Rezoning Transportation Analysis
Petition Number: Insert Zoning Petition # 2021-007
General Location Identifier: Tax ID 08113110

Revision Log:	Date	Description
	03-25-2021	First Review (WB)
	04-19--25-2021	Second Review (WB)

SITE PLAN

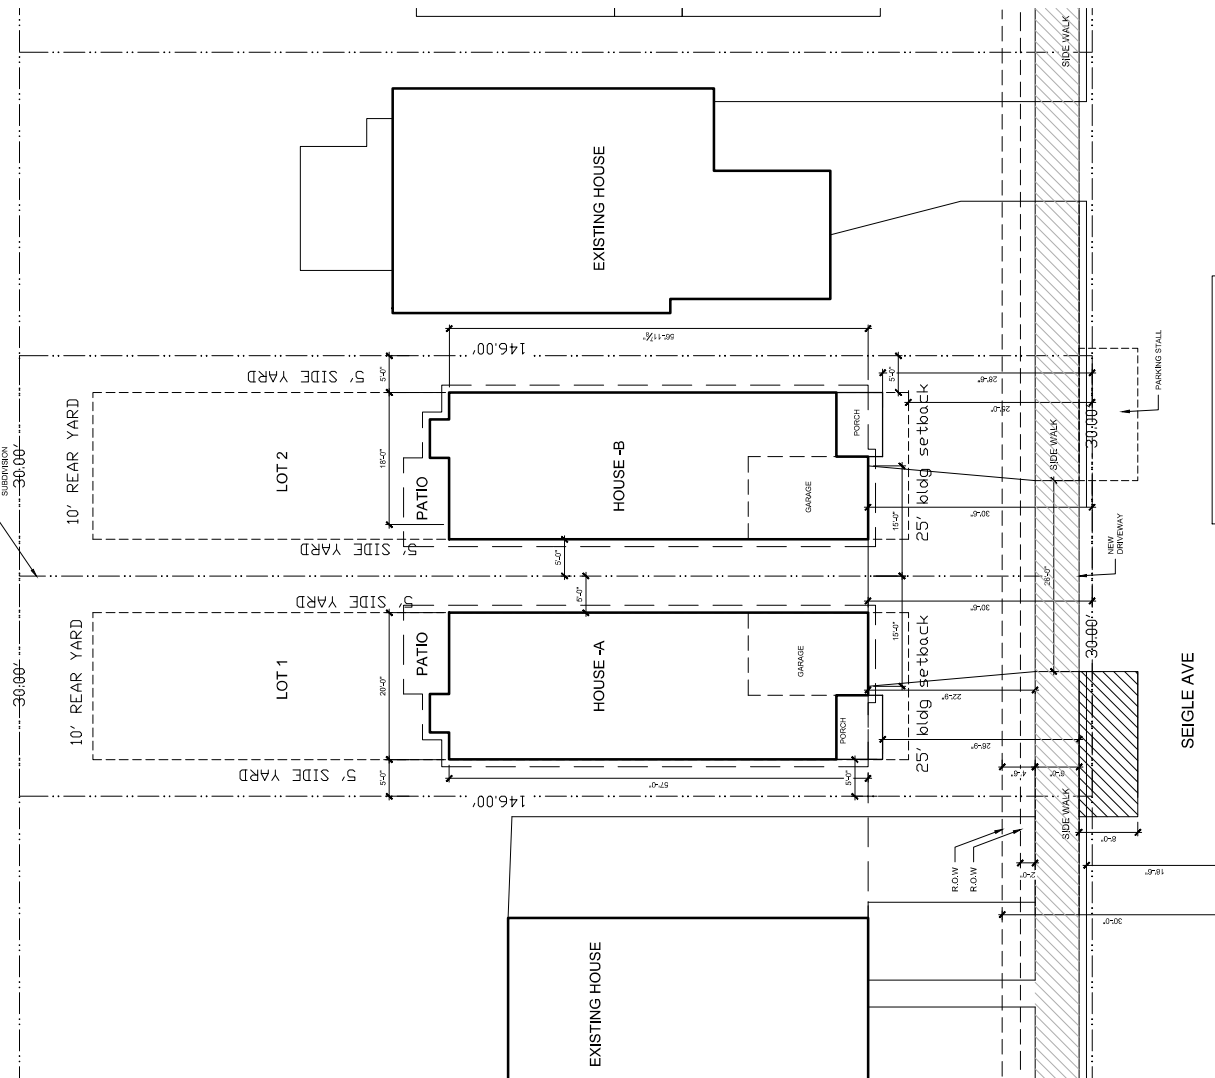
6. Add a site plan note specifying dedication and fee simple conveyance of all rights-of-way to the City before the site's first building certificate of occupancy is issued is needed. CDOT requests rights-of-way set at 2' behind back of sidewalk where feasible.
